From: Amanda Scholes on behalf of Planning.Responses
Sent: 16 May 2017 09:24
To: Planning Scanning
Subject: FW: Planning Consultation on LU/142/17/DOC

Comments in respect to the following drainage conditions;

APPLICATION NO: LU/142/17/DOC

Site Address: The Old Dairy Church Street Littlehampton BN17 5EL

DRAINAGE LAYOUT
SHEET 1 OF 2

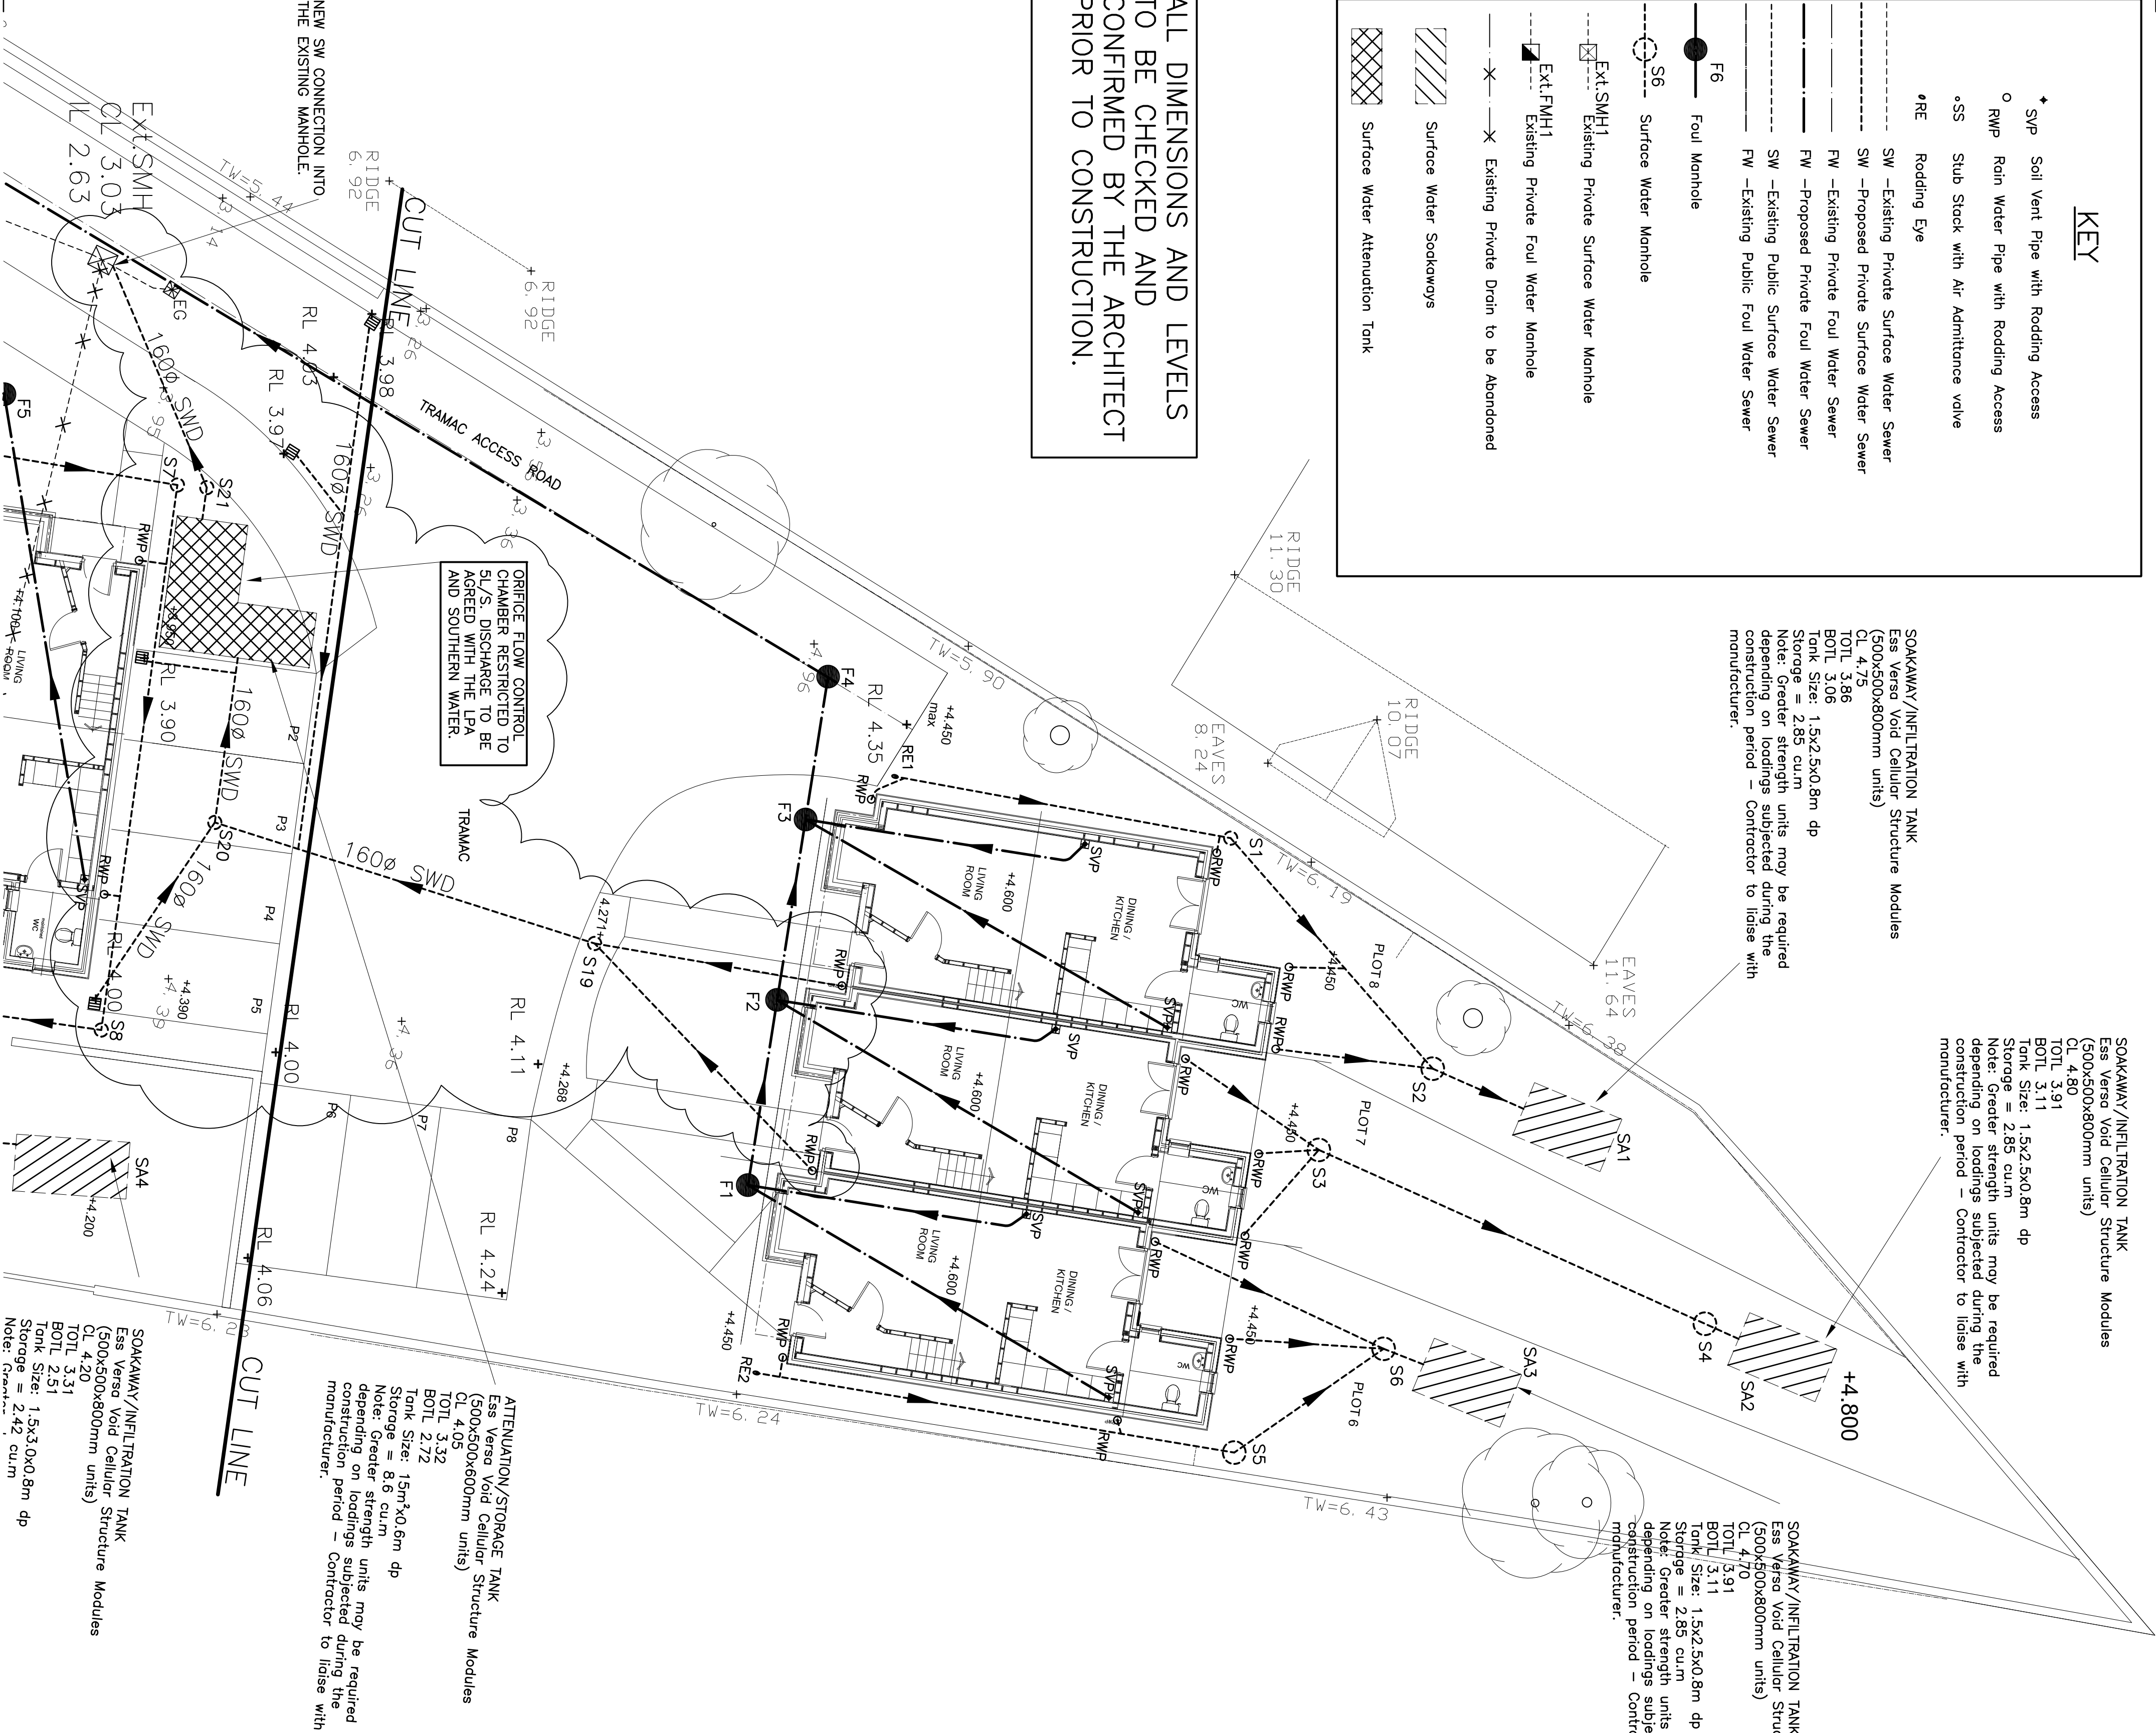
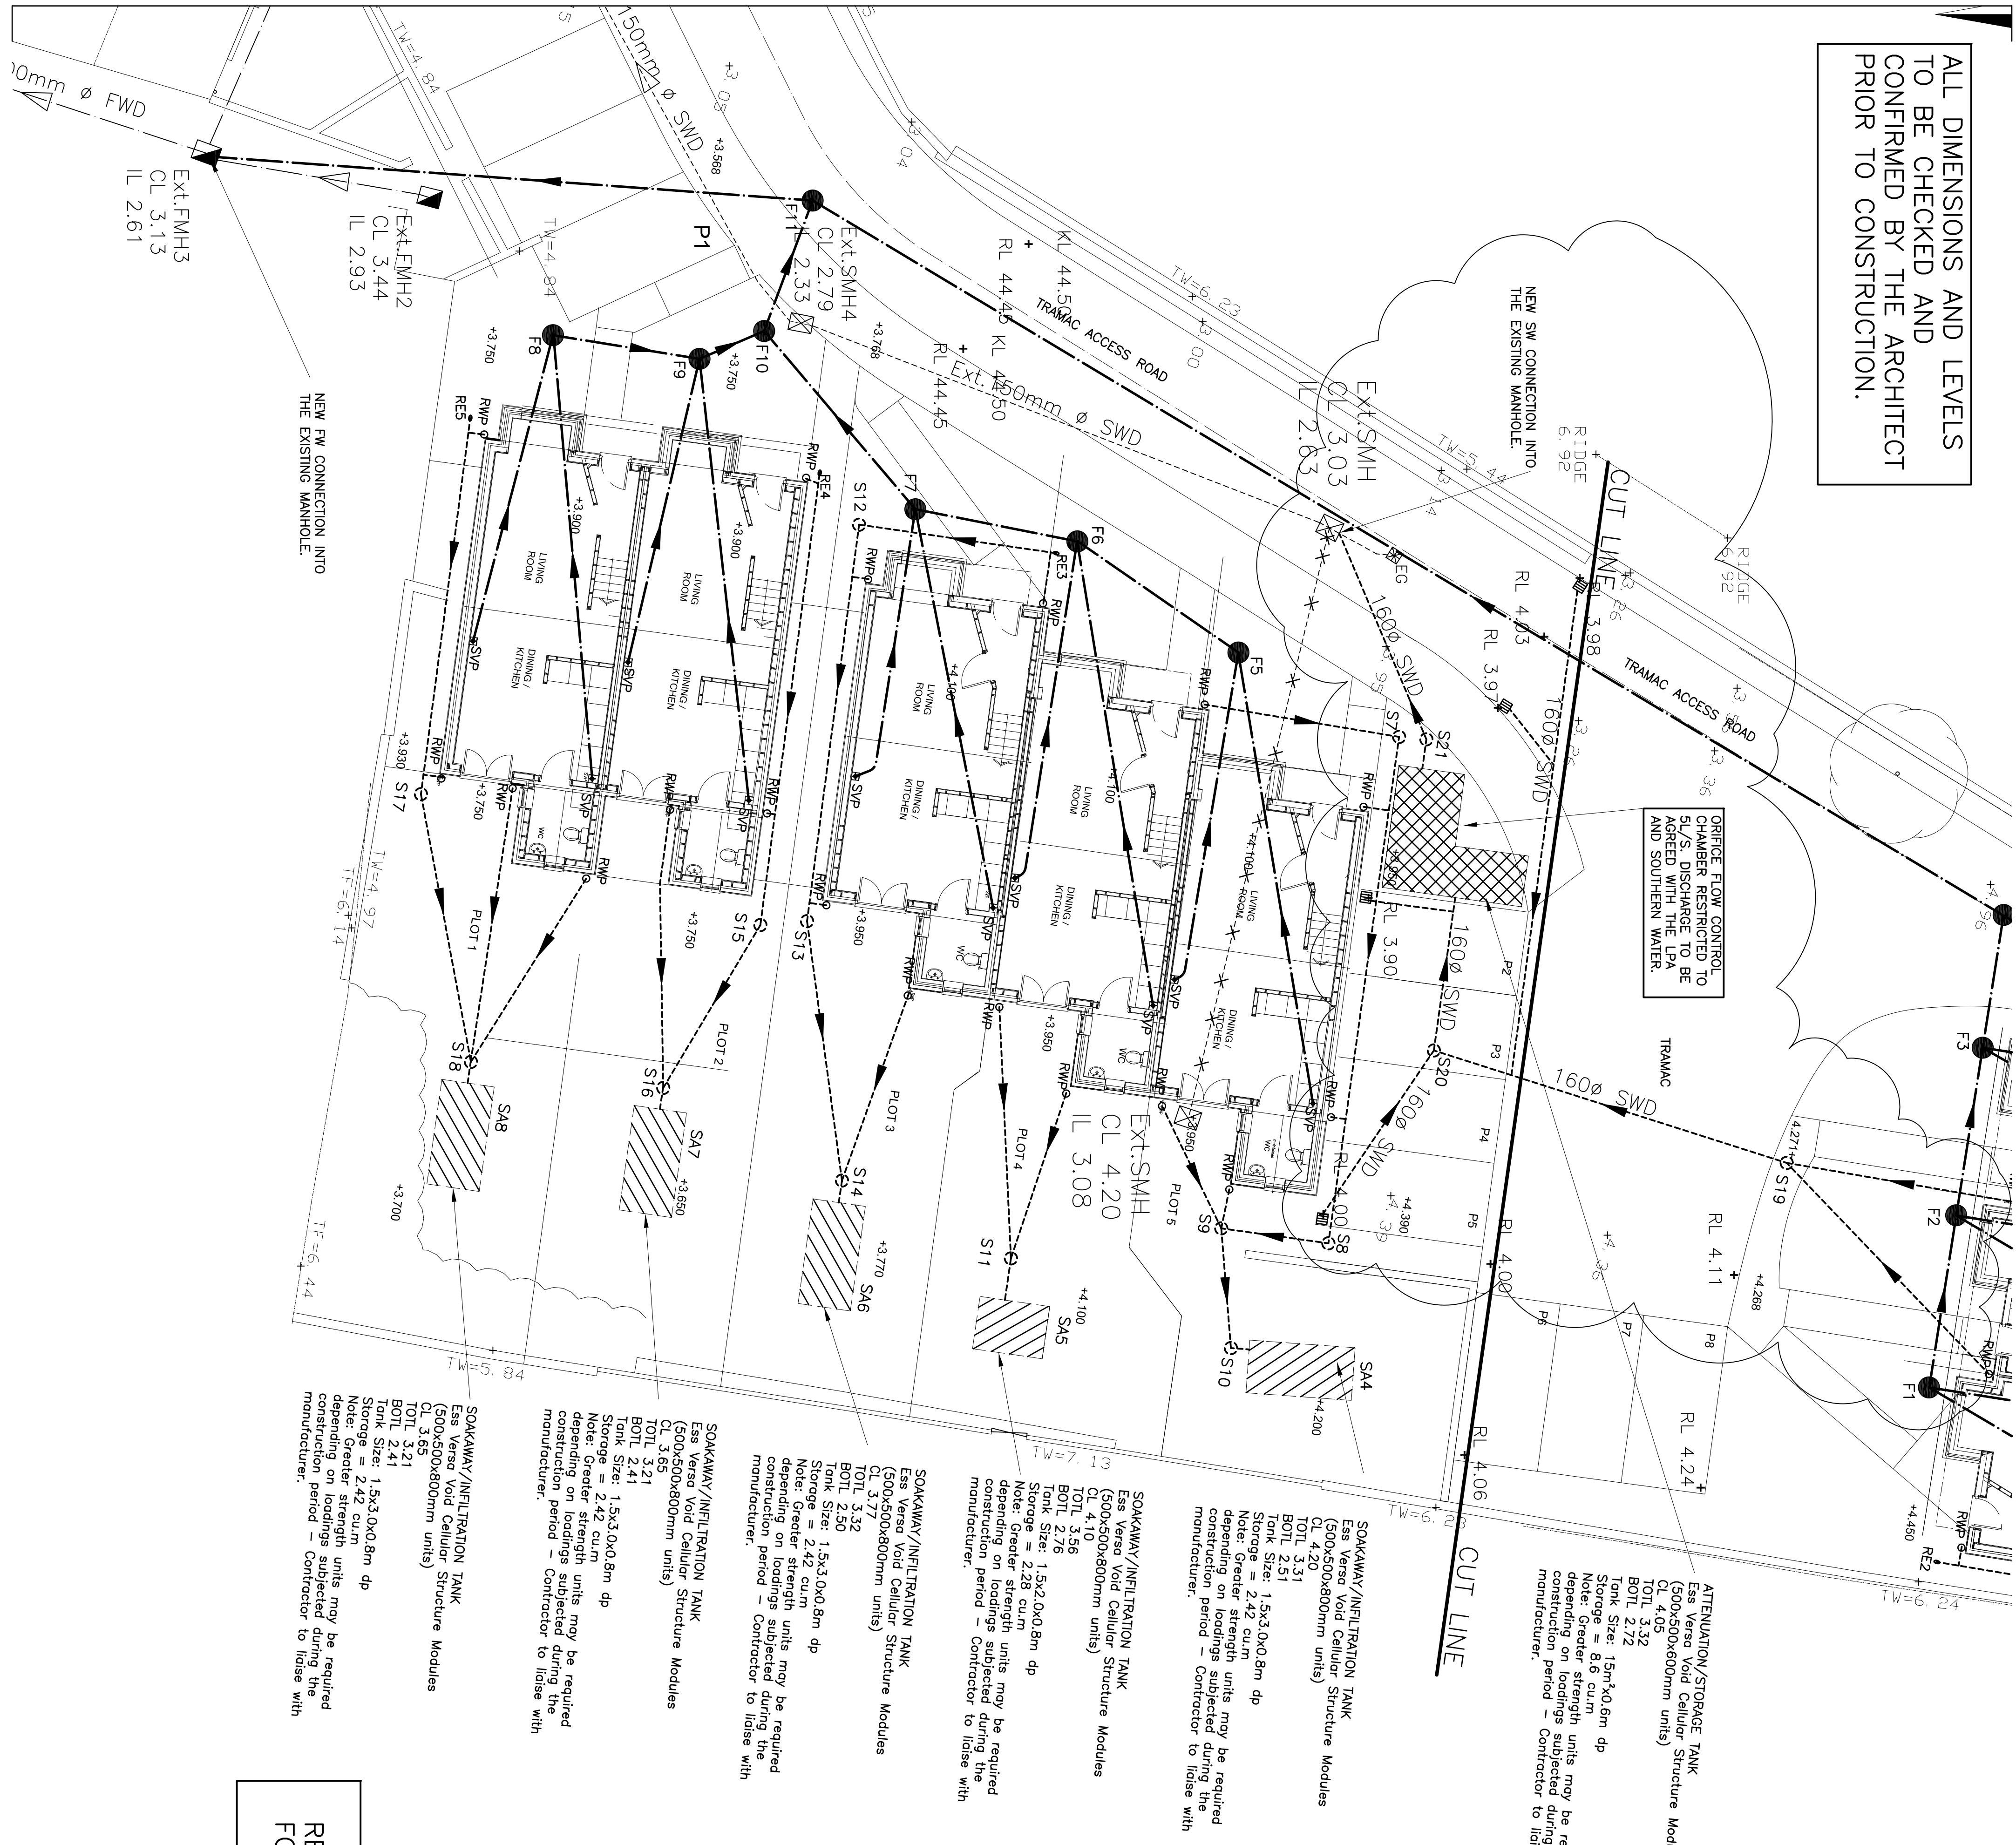
Only part of the site is being proposed to infiltrate into the ground. Given the favourable ground conditions, the entire site should infiltrate to ground without a need to discharge to the public surface water sewer, unless there is a very good reason not to do so. The design should therefore be amended to suit.
